Subject: Section 78 Appeal relating to refusal of Planning Application 2023/0758 for the site of West Green Recycling

I have reviewed the Noise Impact Assessment produced by Spire Environmental supporting the appeal above, and I have the following comments:

Figure 2: Noise monitoring locations

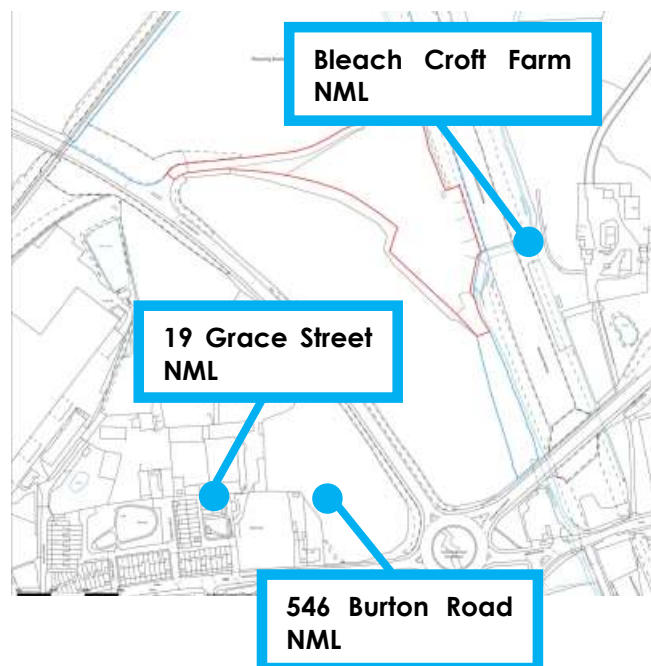
- During the measurement period between 27th September and 4th October 2023, there was light rain noted on 7 out of 8 days and wind speeds of 5m/s or above on 5 out of the 8 days used to measure sound levels. These unfavourable meteorological conditions provide increased uncertainty about the measured results.

- A weather station at Leeds Bradford Airport was used to determine meteorological conditions, however, an anemometer should have been used to measure wind speed and direction at the measurement site as stated in BS4142, which also states that measurement when the ground is wet is highly discouraged

- The site specified for housing, although closer to West Green Way is also much closer to West Green Recycling and is not shielded by the 5m high soil bund, that 19 Grace Crescent is, so the sound monitoring data in this report again poses a more uncertainty, also the activity at West Green Recycling may be audible at the allocated housing land and would therefor potentially require some character corrections on the rating level possibly increasing it to being +5 or even +10 above the background level

Due to the points raised above, I do not consider that the Noise Impact Assessment produced for the appeal is appropriately relevant for the land allocated for housing. So I would recommend that another noise impact assessment is carried out, under appropriate conditions relating to the allocated housing land as a potential receptor.
